**NOVEMBER 19, 2024**  
**PROJECT NO: 1909-5772**  
**SENT VIA: EMAIL**  
**JOSIANE.GERVAIS@OTTAWA.CA**

**RE: TRANSPORTATION IMPACT ASSESSMENT UPDATE LETTER**  
**6160 THUNDER ROAD AND 5348 BOUNDARY ROAD**  
**CITY OF OTTAWA**

This update letter was originally submitted in August 2024. Following receipt of agency comments dated October 25, 2024, from Josiane Gervais via Stephan Kukkonen, this update letter was updated to address the transportation related comment from the City, which is outlined below with Crozier's response:

03 SITE PLAN
SP-A01 SCALE: 1:1500

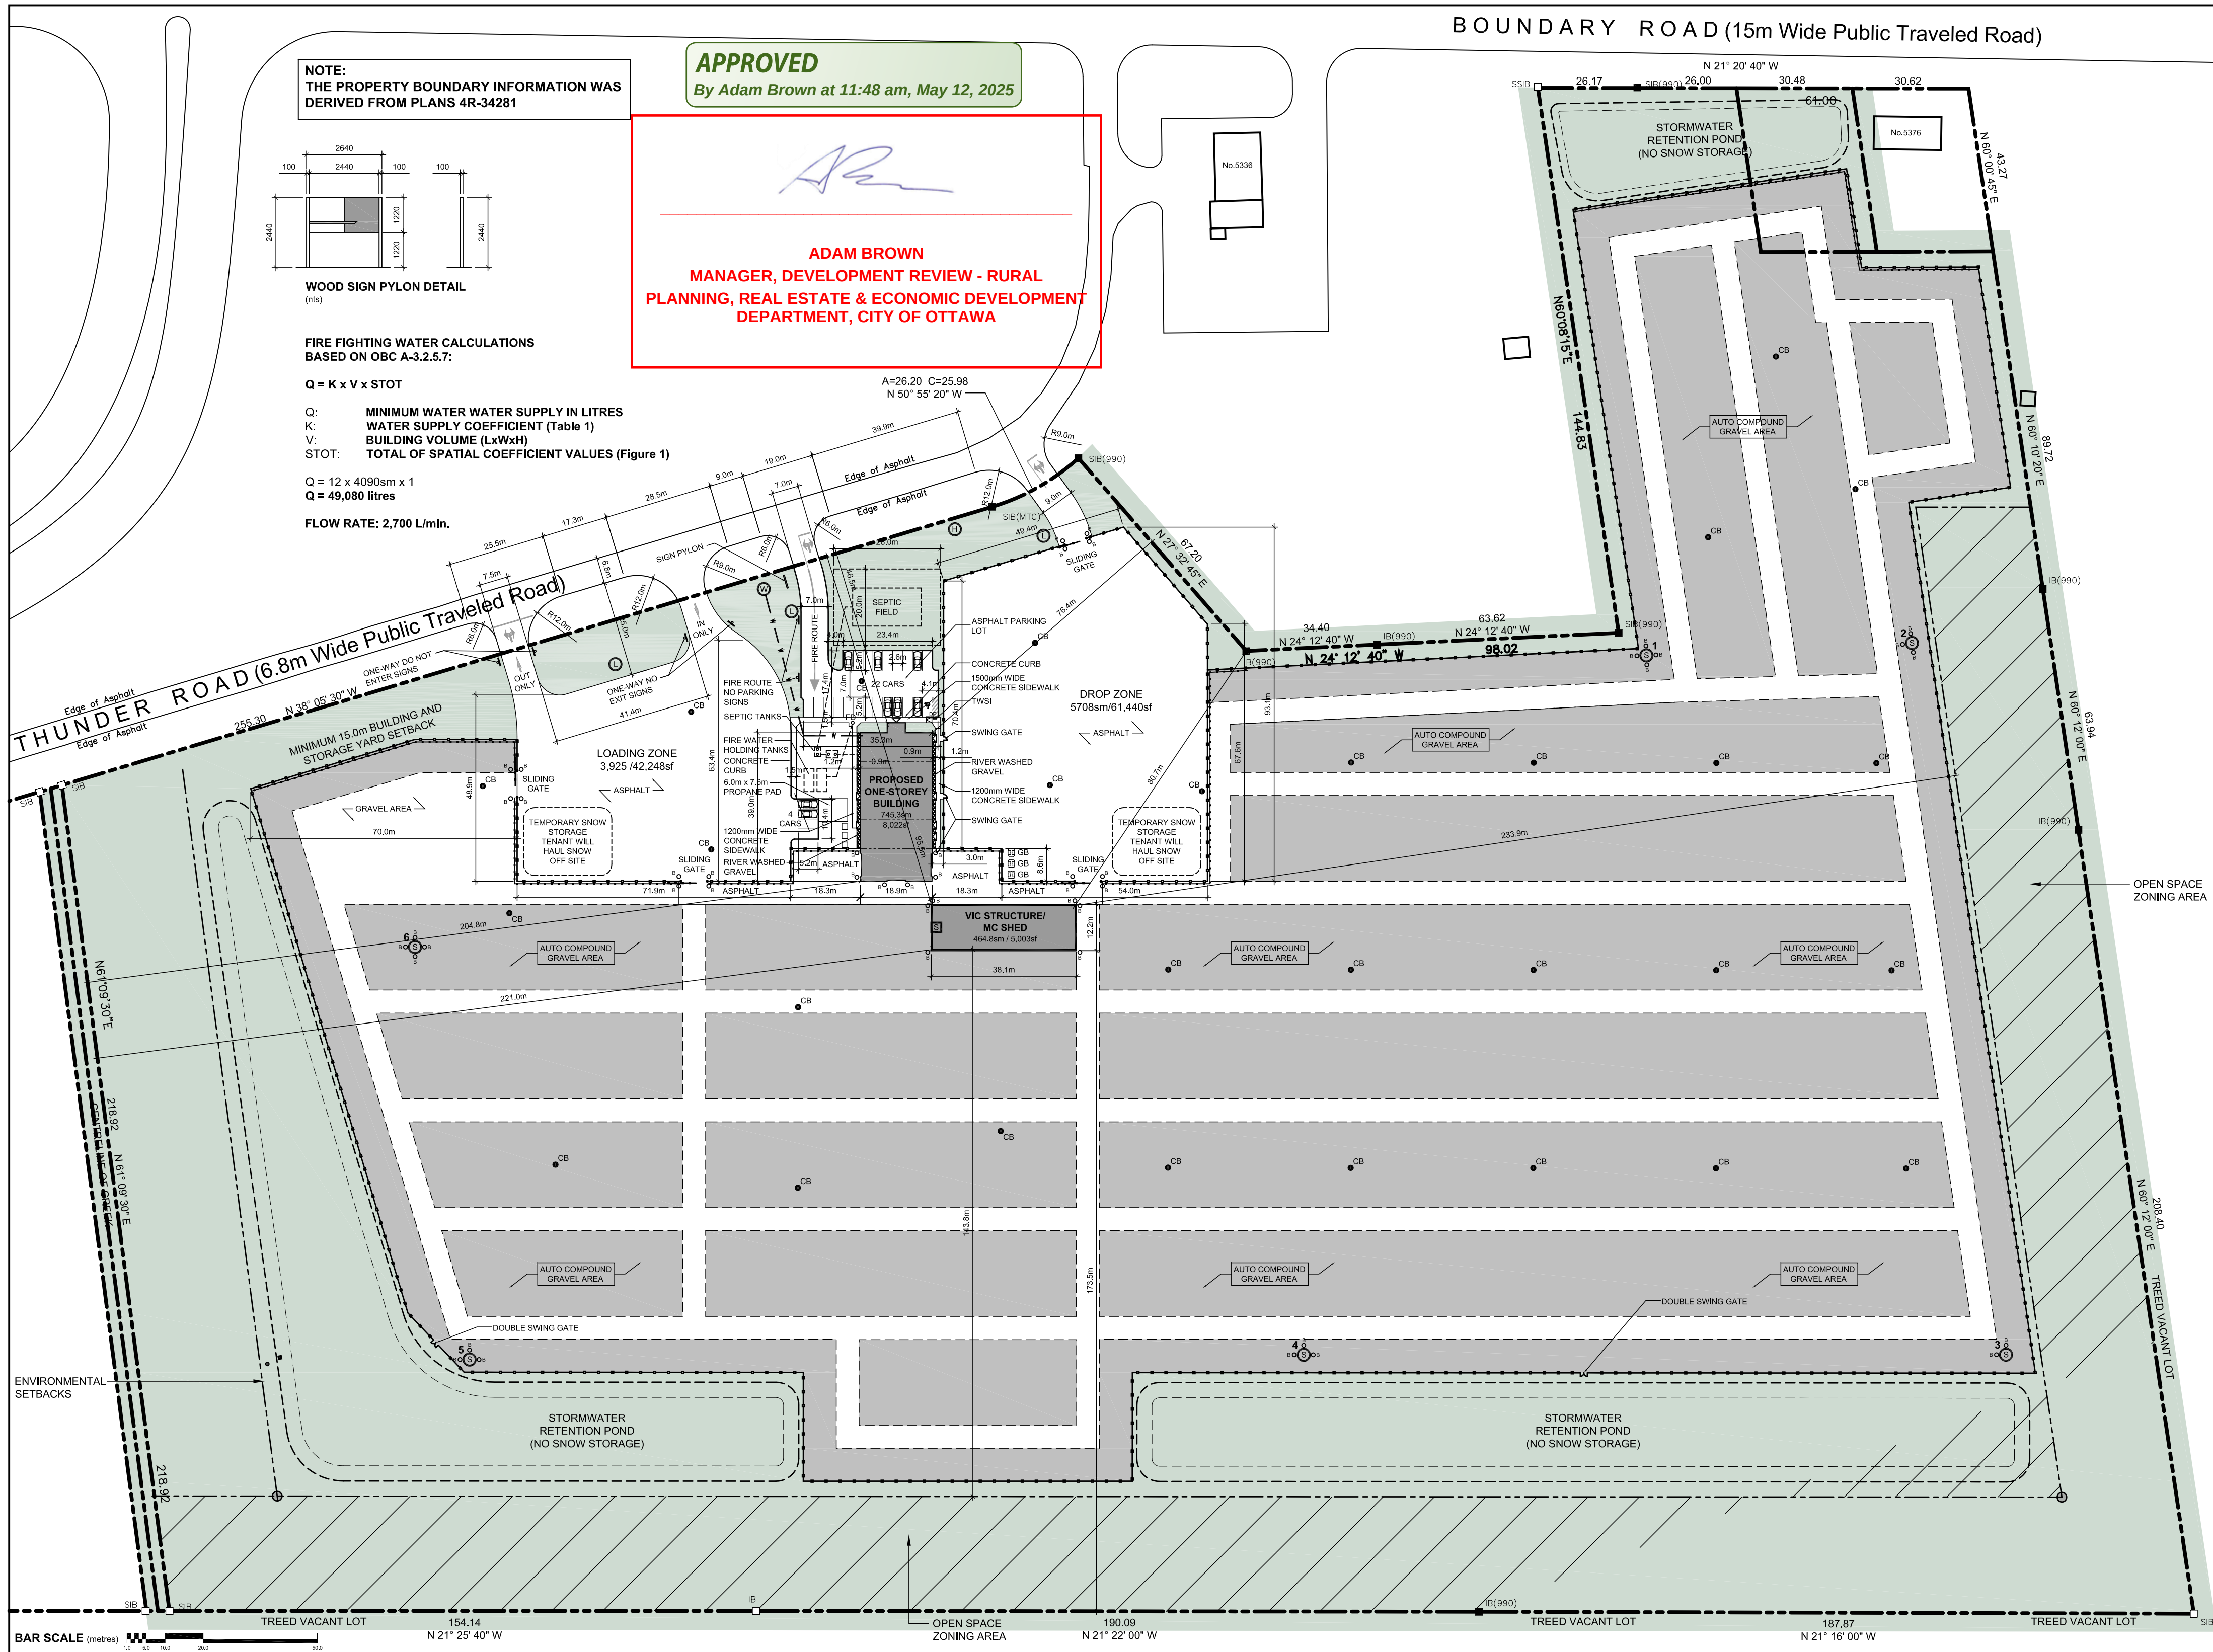
*Attachment D – Sightline sketches: The sightline analysis assumes that the property across the street will remain vacant and free of development and vegetation. Because a significant portion of the site across the street is utilized for the sight-lines analysis, staff have concerns that future development will impact these sightlines. Review sight-line analysis assuming a hypothetical development of the 6165 Thunder Rd property (i.e. show property lines and building setback lines as per zoning on the plan) and identify available sight distances under a future time horizon.*

**Crozier Response:** Crozier coordinated with the City and prepared updated sight line figures presented in **Attachment D**.
